City of Albuquerque

RE: DRURY INN @ 25 DEVELOPMENT (F-17/D82)
(4310 The 25 Way NE)
ENGINEERS CERTIFICATION FOR CERTIFICATE OF OCCUPANCY
ENGINEERS STAMP DATED 11/8/2001
ENGINEERS CERTIFICATION DATED 5/29/2003

Re: Drury Inn (Tract J-1-A, The 25 Development) Grading & Drainage Plan, Engineer's stamp dated 11-08-01 (F17/D82)

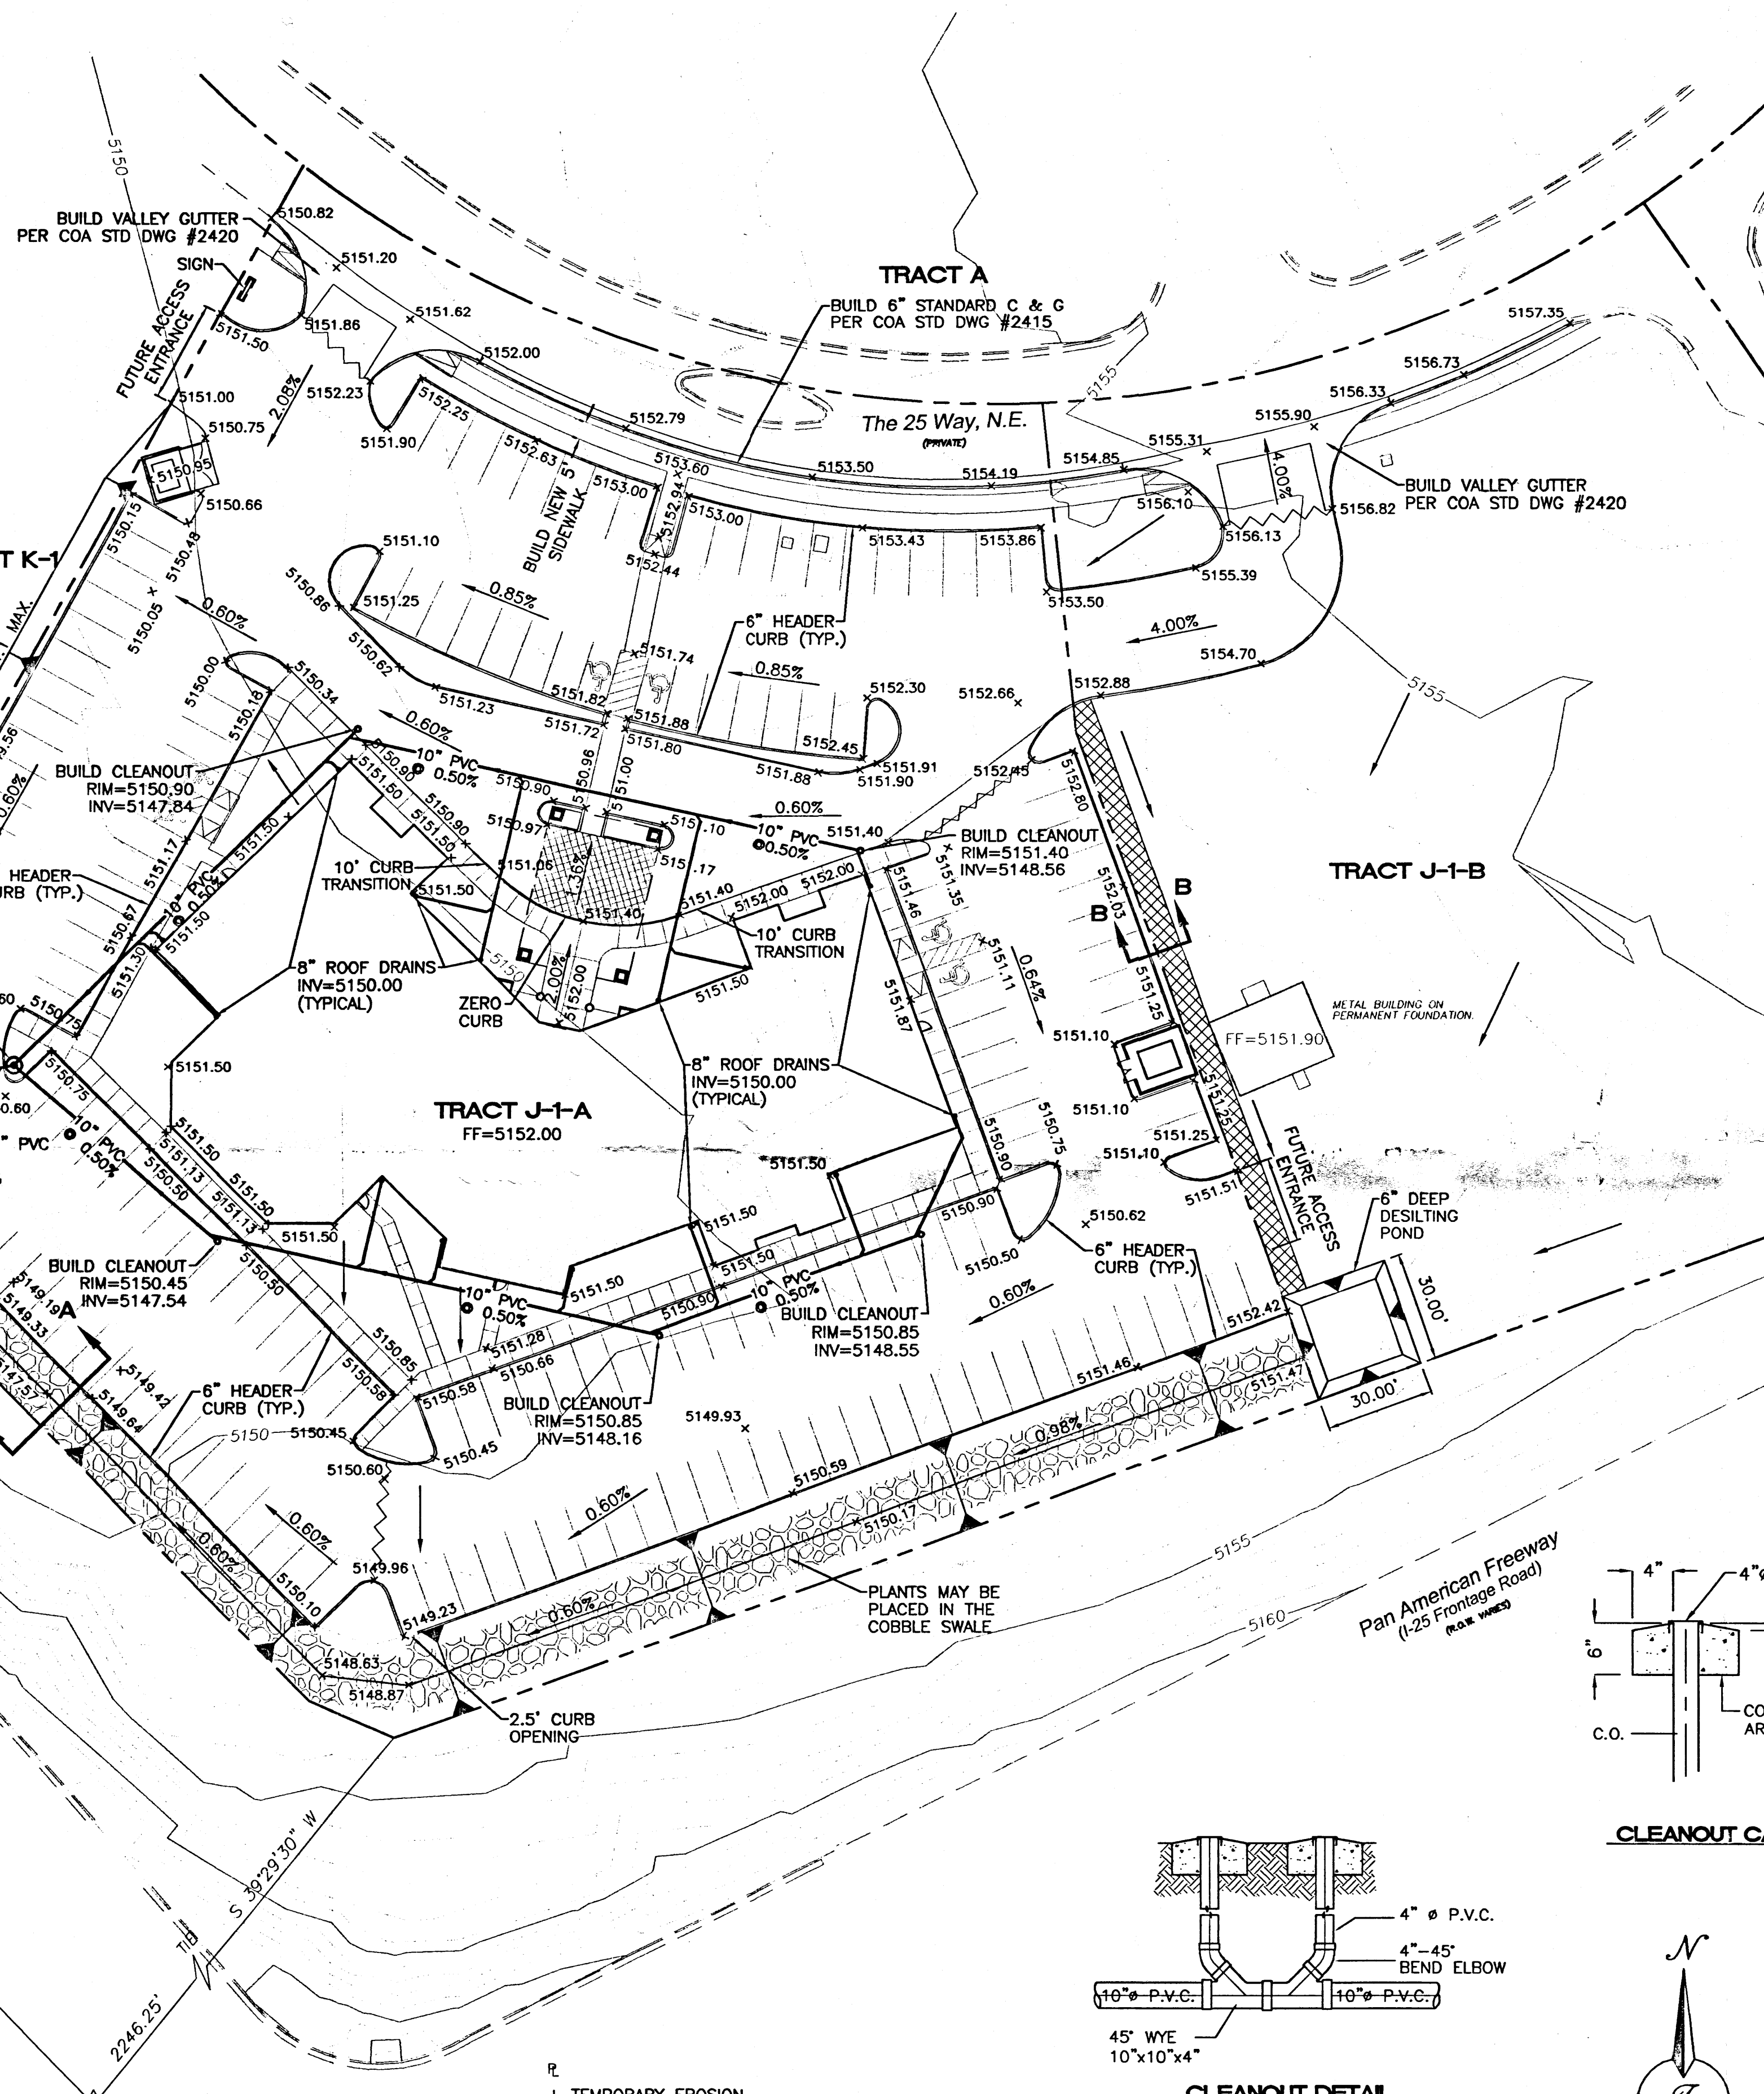
- NMSHC Monument I-25-18 is a valid horizontal control point. However, it is not valid for a vertical benchmark since trigonometric methods and not spirit leveling obtained its elevation (see attached Control Data sheet, printed from the cabq.gov web site). Please provide a proper vertical benchmark.
